# DRB CASE ACTION LOG (PREL & FINAL)

DRB Application No.: 05DRB-00010 (P&F)

Project # 1002727

Project Name: BEL AIR SUBDIVISION

**PLAT OF  
TRACT A-1  
BLOCK 105  
BEL-AIR SUBDIVISION  
CITY OF ALBUQUERQUE  
BERNALILLO COUNTY, NEW MEXICO  
DECEMBER, 2004**

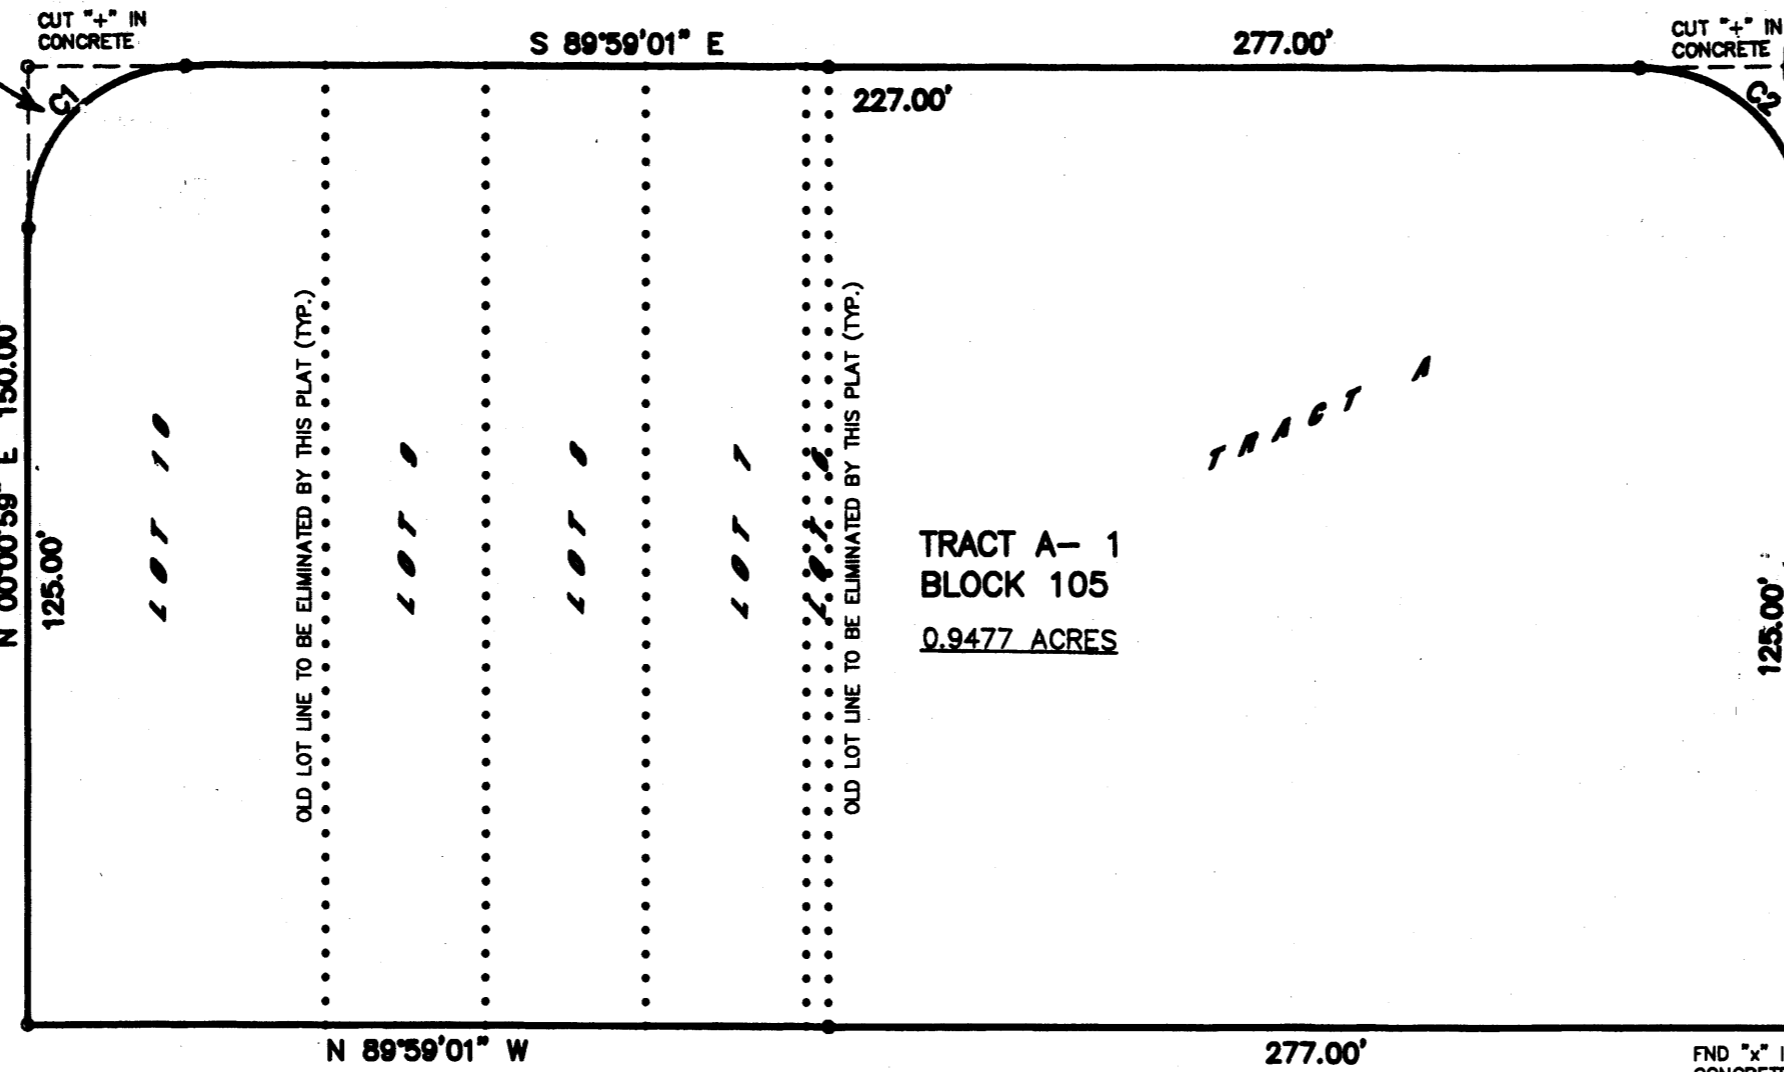
TRANSPORTATION: NEED SITE SKETCH w/ DIMENSIONS TO  
EVALUATE RADIUS DEDICATIONS, S.W., ETC  
SIA

- ~~16. **Project # 1002727-**~~  
05DRB-00010 Minor-Prelim&Final Plat  
Approval
- DAC ENTERPRISES INC agent(s) for PEGGY DASKALOS-LYCOU request(s) the above action(s) for all or a portion of Tract(s) A, Lot(s) 6-10, Block(s) 105, **BEL AIR SUBDIVISION**, zoned C-2, located on MENAUL BLVD NE, between ALVARADO DR NE and PALOMAS DR NE containing approximately 1 acre(s). [REF: 04ZHE00955] (H-18) **THE PRELIMINARY PLAT WAS APPROVED WITH FINAL SIGN OFF DELEGATED TO TRANSPORTATION DEVELOPMENT FOR POSSIBLE RADII DEDICATIONS AND TO PLANNING FOR AGIS DXF FILE.**

TRANSPORTATION: ALERT SITE SKETCH w/ DIMENSIONS TO  
 EVALUATE RADIUS DEDICATIONS, S.W., ETC  
 OK w/ 8-5-05
